OFFICIAL NOTICE OF DECISION

CITY OF ALBUQUERQUE
PLANNING DEPARTMENT
DEVELOPMENT REVIEW BOARD

3. Project # 1002567

ADVANCED ENGINEERING & CONSULTING LLC agent(s) for STEVE KIRK request(s) the above action(s) for all or a portion of Lot(s) 5-A-1, COLEMAN ADDITION (to be known as **HACIENDA DE LOIS SUBDIVISION**) zoned R-2 residential zone, located on 12TH ST NW, between MENAUL EXTENSION NW and LA POBLANA NW containing approximately 1 acre(s). [REF: 06DRB-00726] (H-13)

SECTION A-A
 NTS

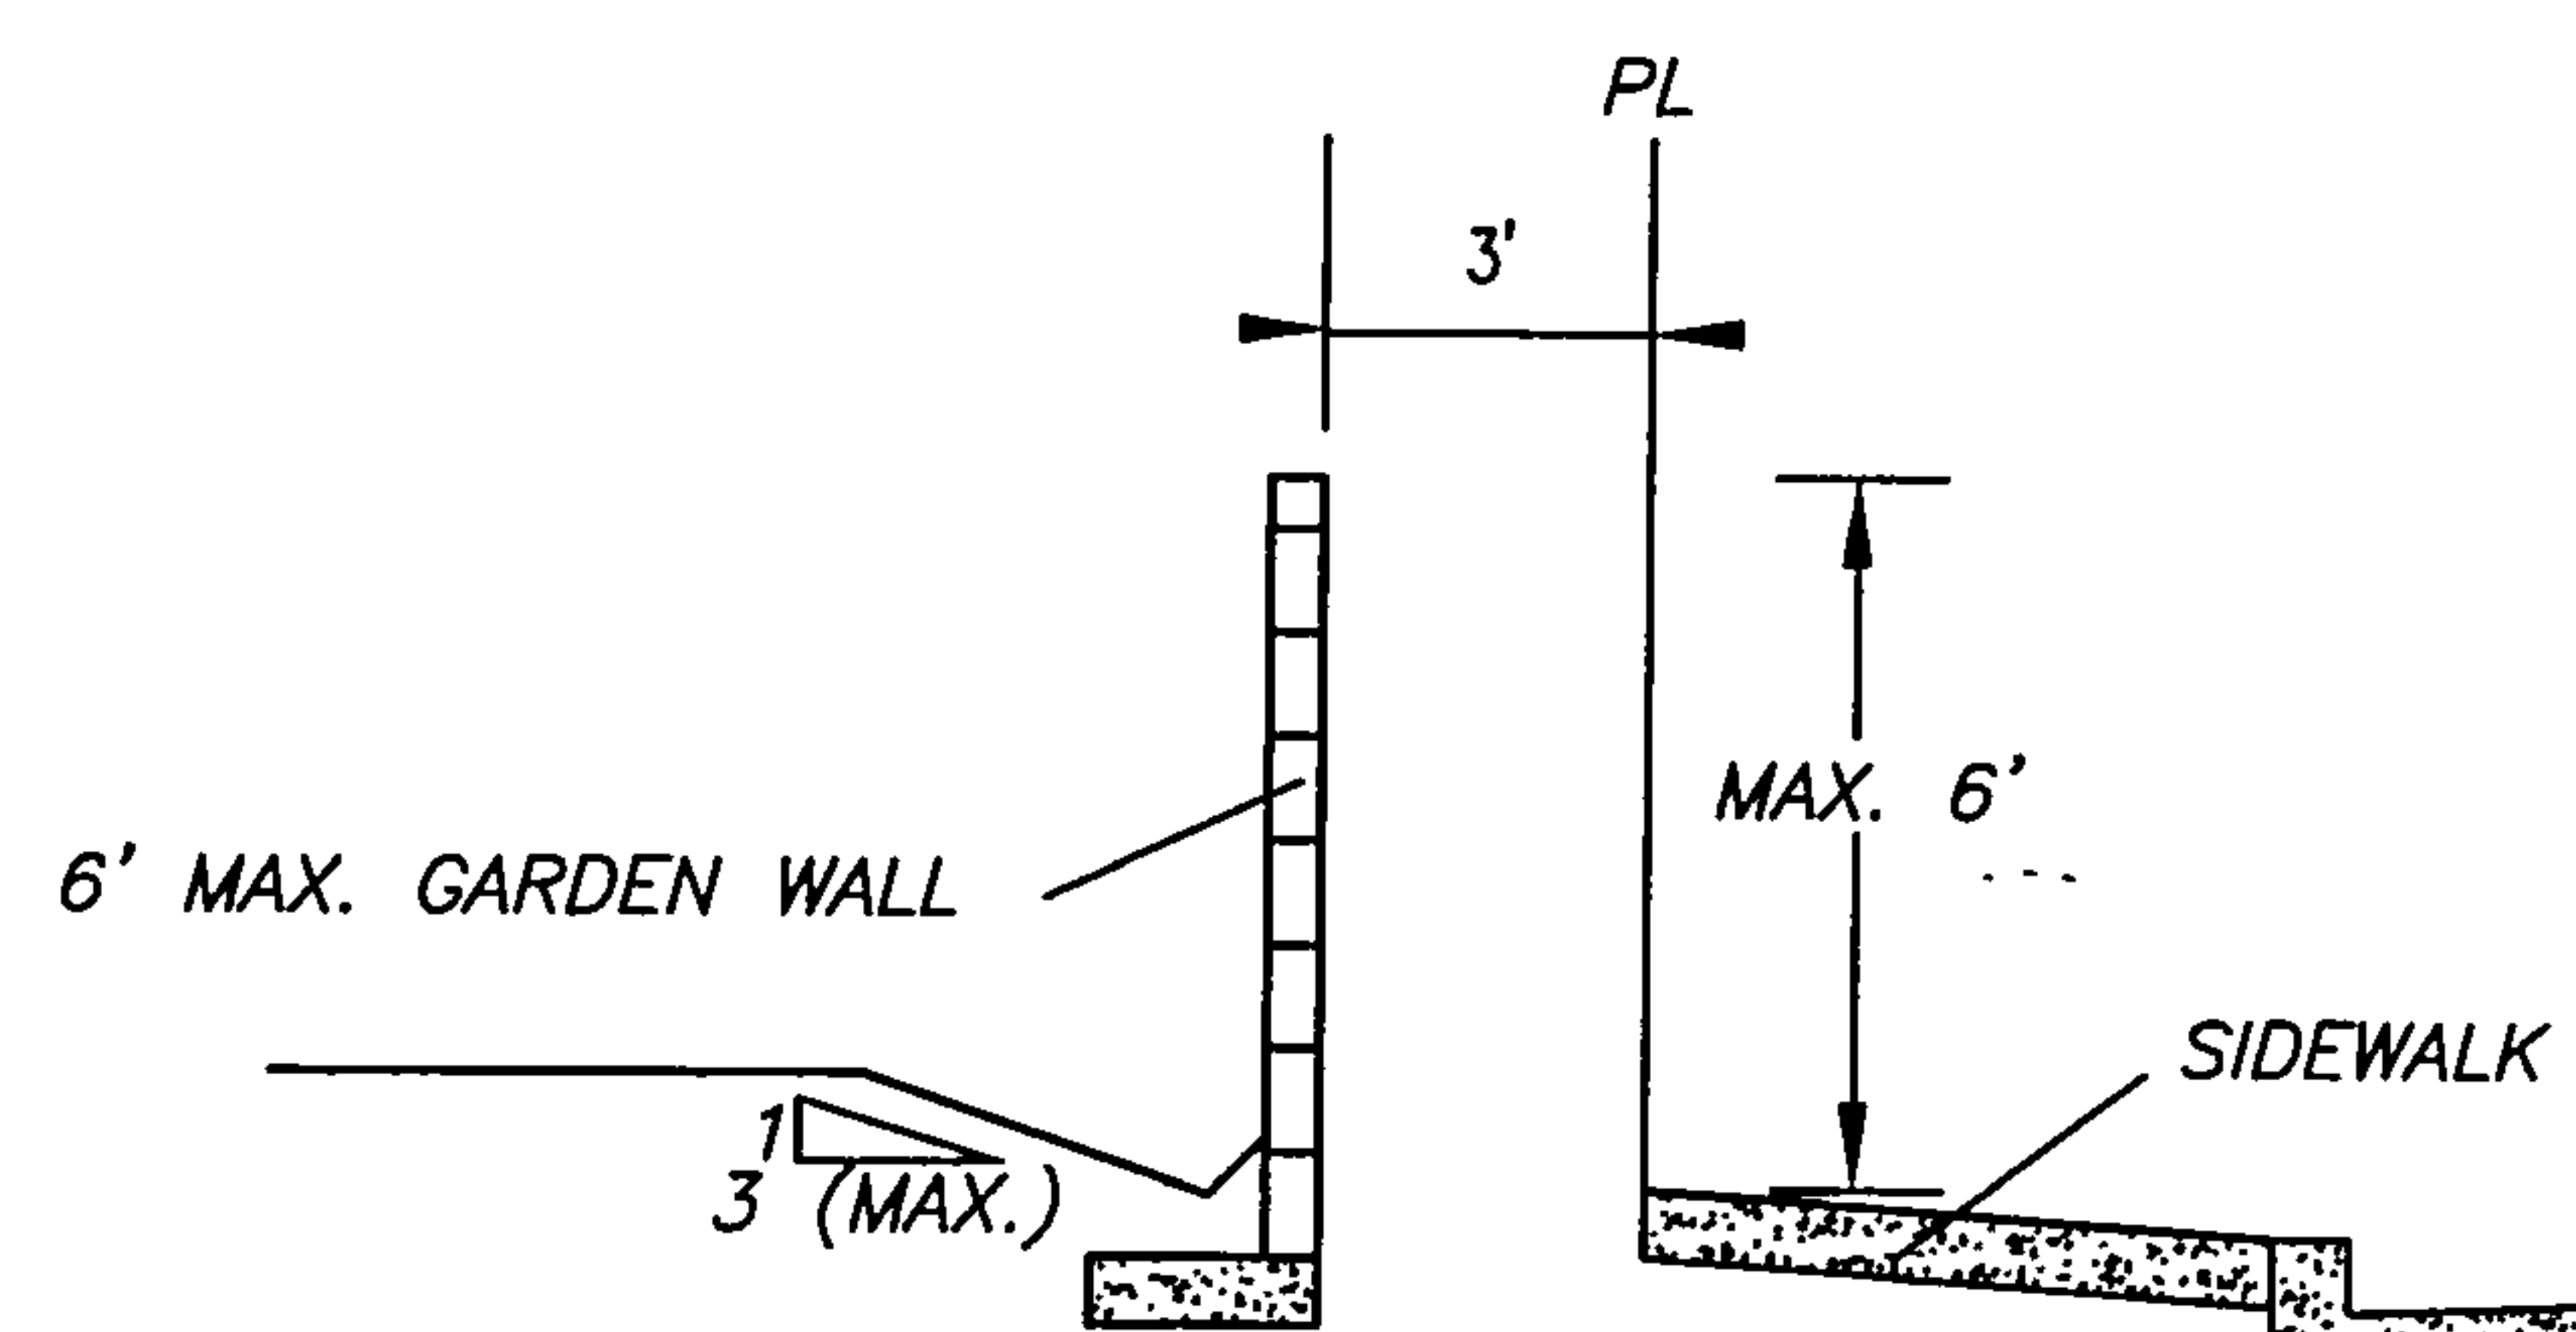
An improved wall design is needed,
